PORTLAND MAINE

June 20, 2013

Re: 12 Romasco Lane – 013-I-019 – R-6 Residential Zone – Permit #2013-01241 –
unpermitted deck and egress stairs & landings

EXTERIOR ELEVATIONS

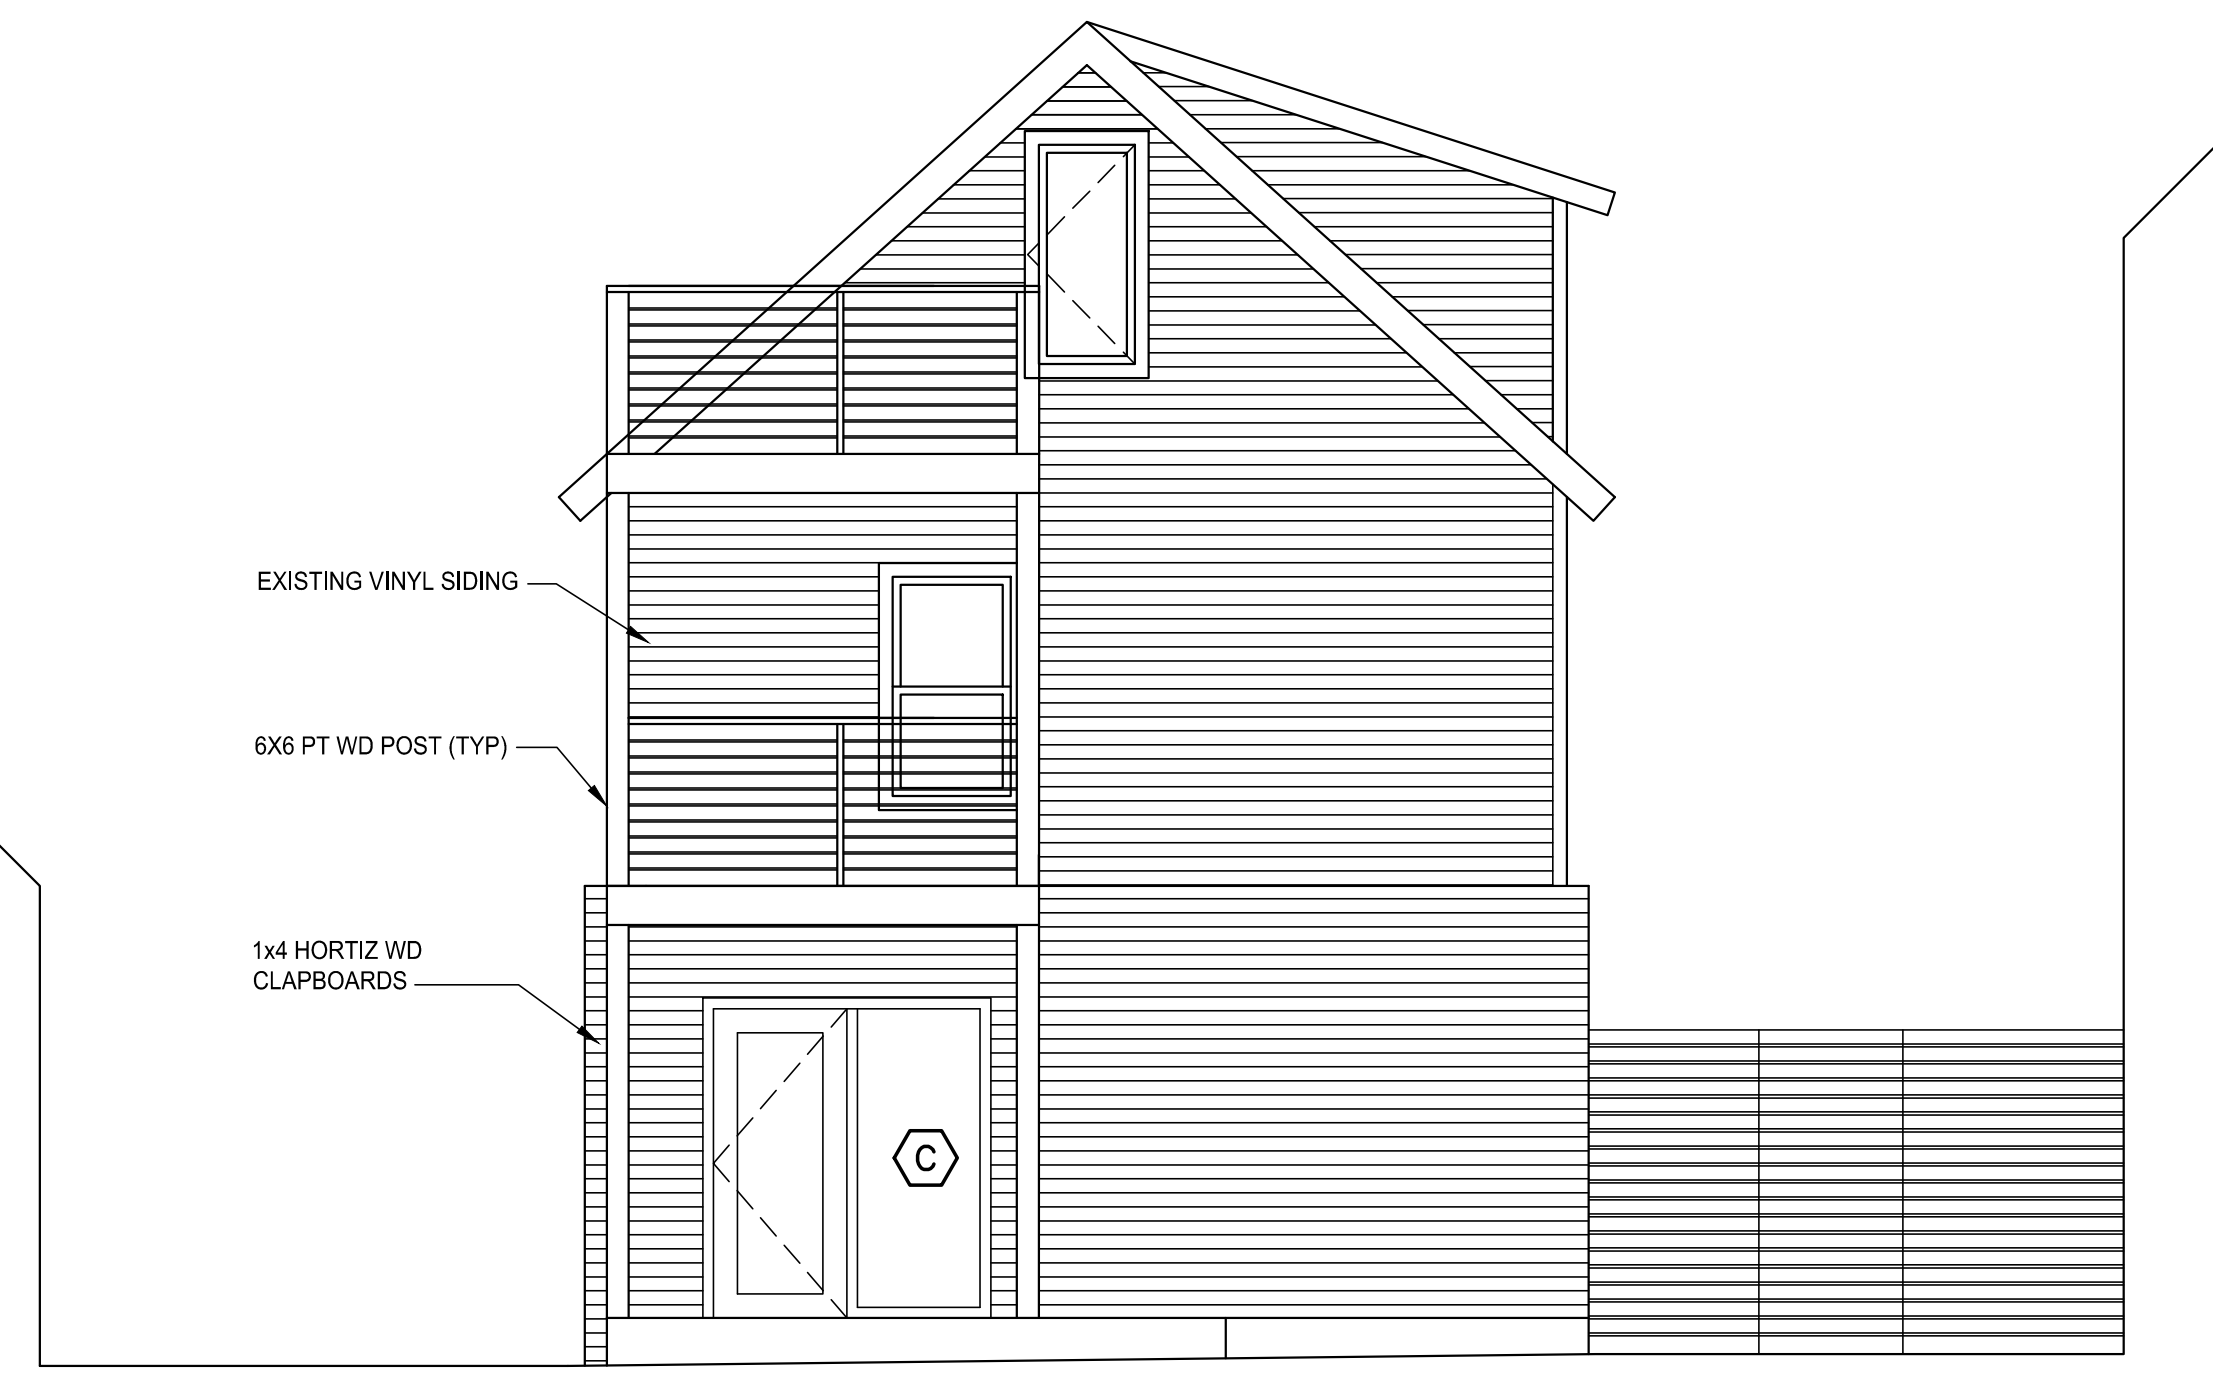
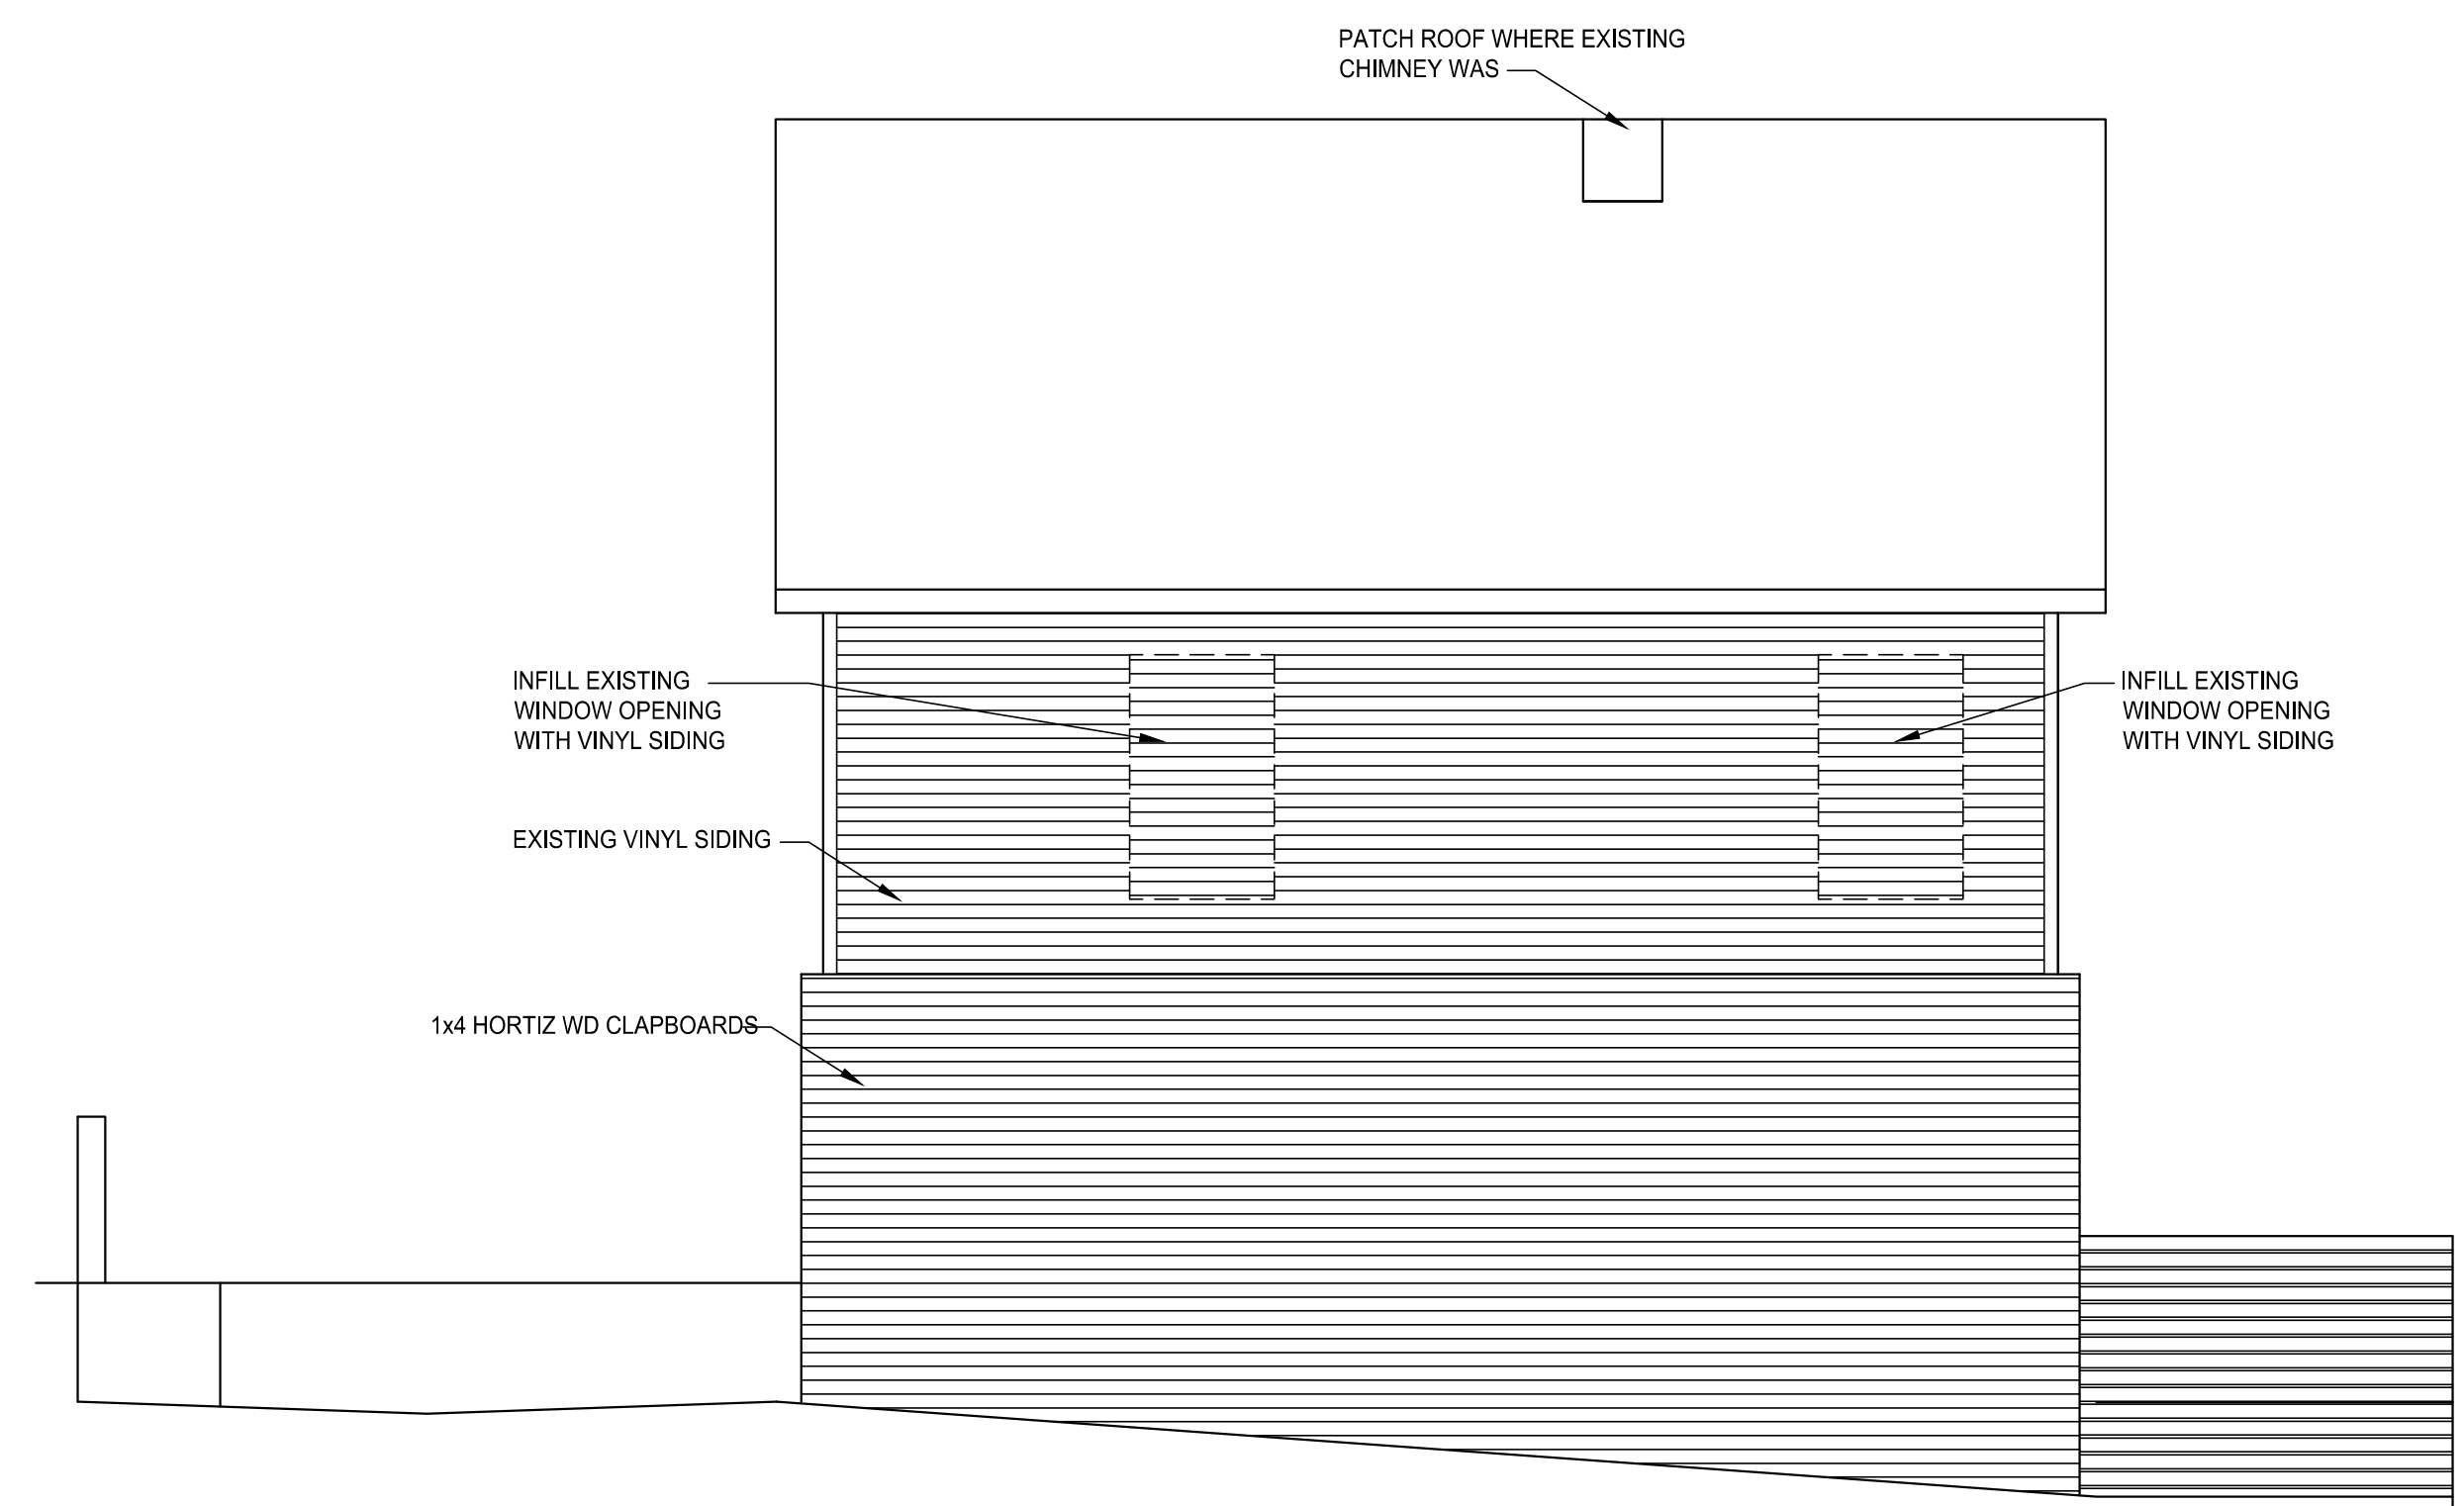
This letter is a follow up to the telephone conversation that we had yesterday. Part of the work that is proposed on the permit is to remove the existing landings and stairs off the rear of the building, and add a second and third floor deck over the existing ground floor deck. The existing and proposed decks go right to the rear property line with no rear setback and the side setback for the existing deck is about 1.4 feet.

12 Romasco Lane is located in the R-6 residential zone. The minimum rear setback [section 14-139(a)(4)(b)] is twenty feet. The minimum required side setback [14-139(a)(4)(c)] is ten feet. The proposed second and third floor decks do not meet either setback. Since the ground floor deck was existing, I researched our files and the assessor's property cards to see if it was permitted. There was no permit for the deck and no footprint of the deck on any of the assessor's cards dating back to the early 1950's. Since the deck was not permitted, it is not legal and since it does not meet the required setbacks it cannot be permitted after the fact. You have thirty days to bring your property into compliance by removing the deck.
